PLAT OF
TRACTS N-1-A & N-1-B
WATERSHED SUBDIVISION
(A REPLAT OF TRACT N-1,
WATERSHED SUBDIVISION)
PROJECTED SECTIONS 17 AND 18,
TOWNSHIP 10 NORTH, RANGE 2 EAST,
N.M.P.M.
ALBUQUERQUE,
BERNALILLO COUNTY, NEW MEXICO
AUGUST, 2023

TRACTS N-1-B, WATERSHED SUBDIVISION zoned **PC**, located on **ARROYO VISTA** between **118TH ST** and **98TH ST** containing approximately 60.08 acre(s). (J-8)

REQUEST: Sketch Plat review for Tract N-1-B Watershed
IDO -2022

Development Facilitation Team (DFT) – Review Comments

PRELIMINARY PLAT  
SAVIO RIDGE  
SUBDIVISION  
(REPLAT OF TRACT N-1-A & N-1-B  
WATERSHED SUBDIVISION)  
CITY OF ALBUQUERQUE  
BERNALILLO COUNTY, NEW MEXICO  
DECEMBER, 2024

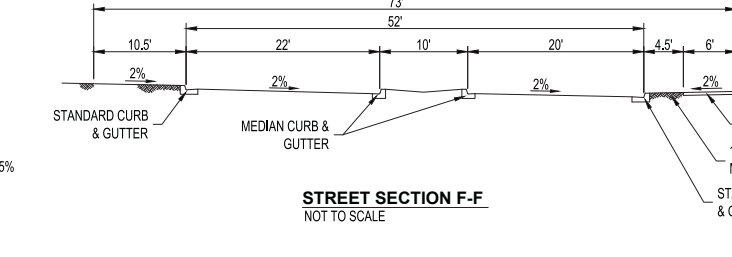
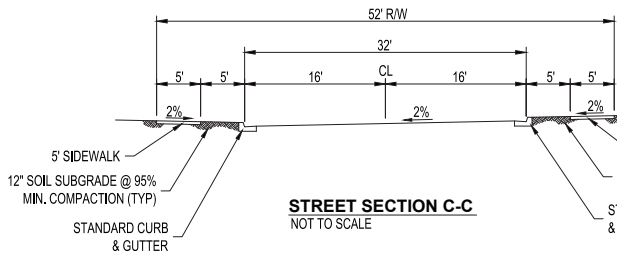
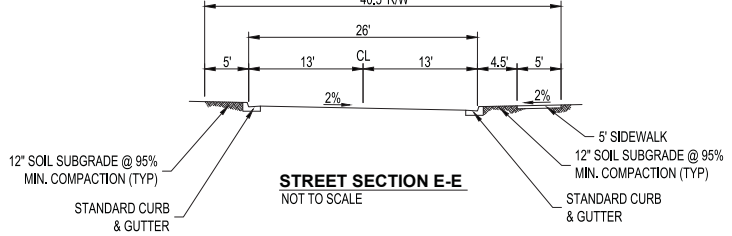
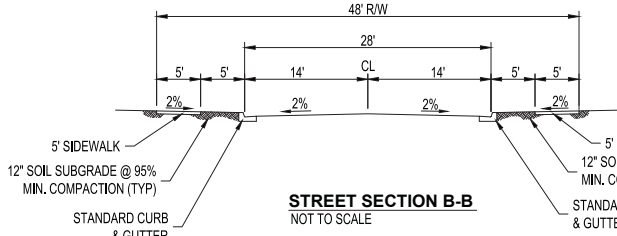
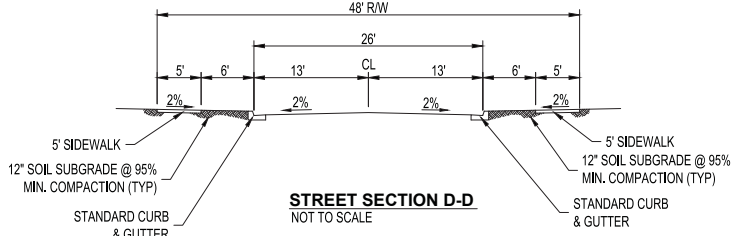
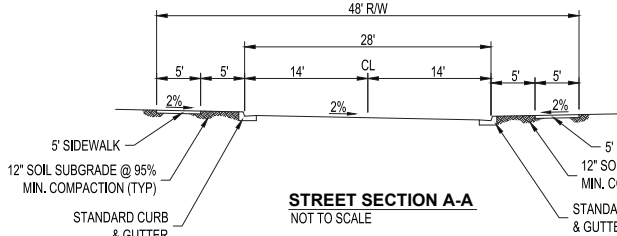
It is noted that a single-loaded street has been placed on the edge of the subdivision adjacent to Petroglyph National Monument which meets of the requirements of 5-2(J).

It would appear that you have been able to keep some block lengths under 600 feet, but some are not.
